From: Martin Hill <Martin.Hill@arun.gov.uk>
Sent: 26 January 2022 09:57
To: Planning.Responses <Planning.Responses@arun.gov.uk>
Subject: RE: Planning Consultation on: BR/4/22/PL

Please see Private Sector Housing comments, below:

Application No: BR/4/22/PL

Description of Works: Enlargement of existing HMO (Sui Generis), single storey rear extension, rear roof dormer, front and rear rooflights (resubmission following BR/79/21/PL).

Proposed First Floor Plan 1:50

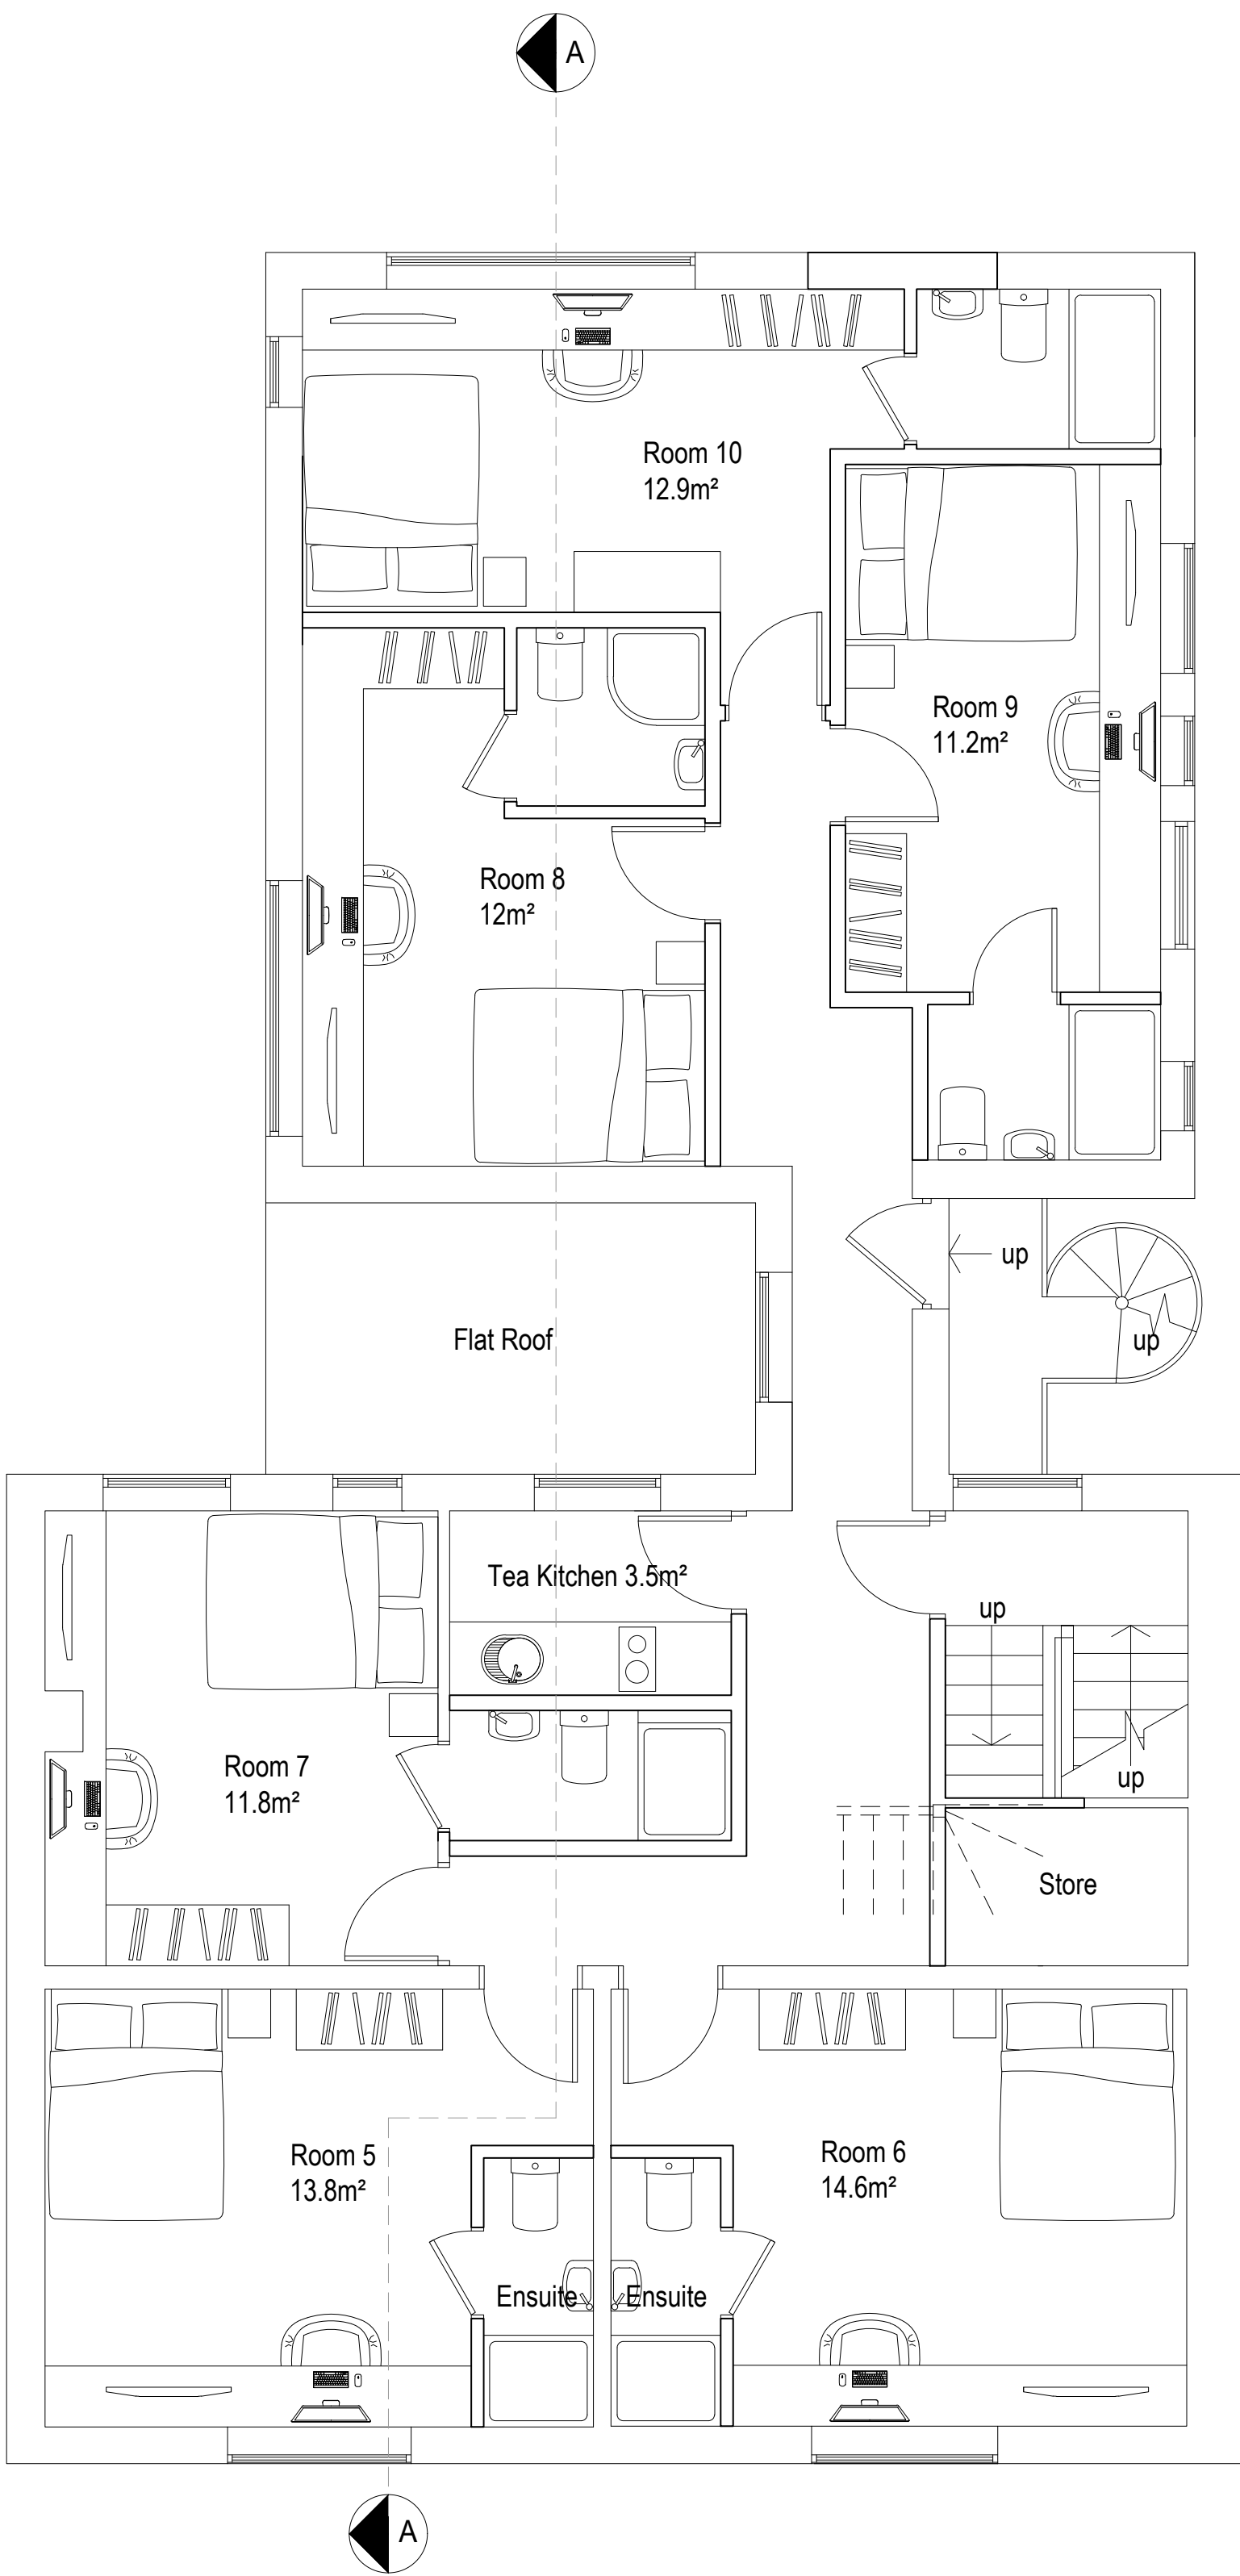
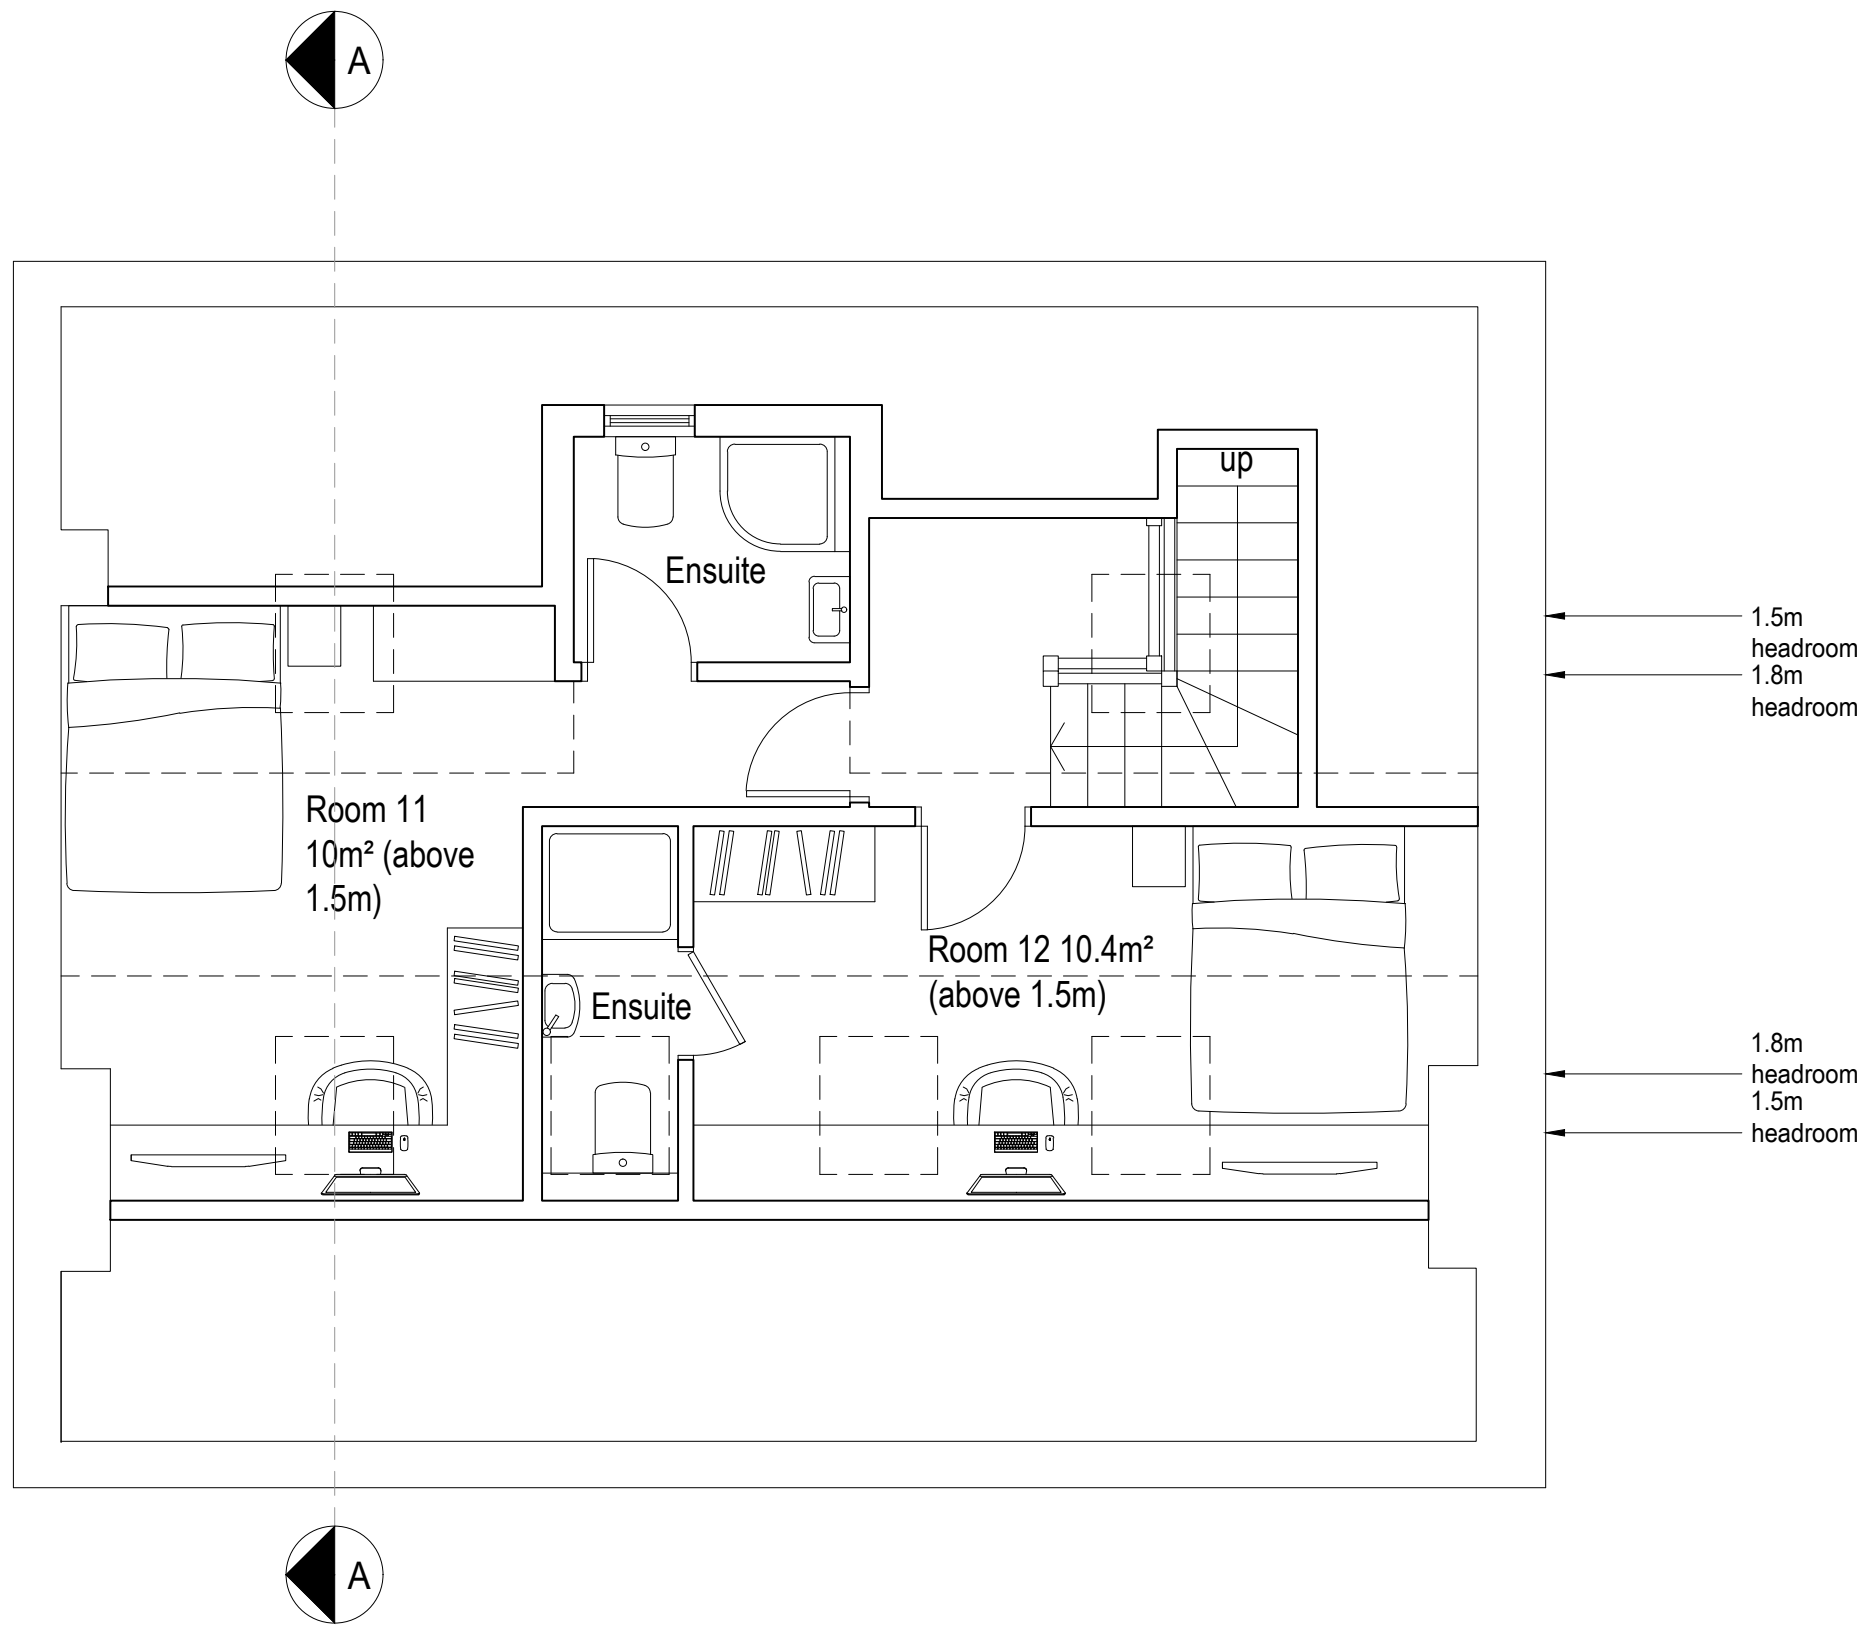
- The internal escape route must provide 30 minutes fire resistance. This includes the provision of 30-minute fire resisting and self-closing fire doors (FD30S) to each bedroom, the communal kitchen area, laundry, tea kitchen, internal staircase on the first floor, external staircase on the first floor and any other risk areas such as cupboards and storage areas along the escape route (unless otherwise to be kept locked shut, in which case self-closing devices may not be needed). N.B. Additional fire doors may be required along the escape route to the ground and first floor if the travel distance is considered excessive. This should be addressed in the Fire Risk Assessment

- Under-stairs areas, including the laundry on the ground floor and store area on the first floor, must afford a minimum 30 minutes fire resistance. The floor, door, ceiling and walls, including the spandrel wall, must be free from holes and lined with a material that has a minimum integrity of 30 minutes fire resistance. Fire doors not in constant use must be kept locked shut at all times.

- Locks fitted to communal entrance doors, all bedroom doors and external staircase door should not require the use of a key, code or card and must be fitted with thumb turn devices to enable a swift and safe escape in the event of an emergency.

- A Grade A, LD2 fire alarm and detection system must be installed. Grade A detection is required in the following areas:
 - Interlinked smoke detection throughout the escape routes

- Interlinked smoke detection to each bedroom
 - Interlinked smoke or heat detection (as determined by the fire risk assessment) to the laundry area on the ground floor

- Interlinked smoke detection to the store area on the first floor landing
 - Interlinked smoke detection to the commercial unit
 - Interlinked heat detection to the communal tea kitchen on the first floor

- Fire blankets must be provided to all kitchen areas
- Emergency lighting must be provided throughout the internal escape routes. Maintained emergency lighting also to be installed to illuminate the external escape stairs and external route along the side of the property.

- Access to the flat roof on the first floor must be sufficiently restricted to prevent persons accessing this area, upon the assumption the flat roof is not intended to be load bearing, the roof is not fitted with safety railings around the perimeter and that it is not a designated escape route.

- The bedrooms on the second floor to the North side of the property only have skylights/roof casements available. As they appear to be the only source of light and ventilation within these rooms, they must meet all of the following criteria;

- Must be able to be fully opened for ventilation during spells of prolonged and heavy rain or snow without allowing it to enter the room;
 - Must have integral passive ventilation even when the window is shut; and

- Must provide a reasonable view. The Housing Health and Safety Rating System (HHSRS) states as a relevant matter that there should be a “reasonable view out of all rooms, other than those where privacy is required, such as bathrooms and WCs”, as this can have a negative effect on mental health, especially over the longer-term
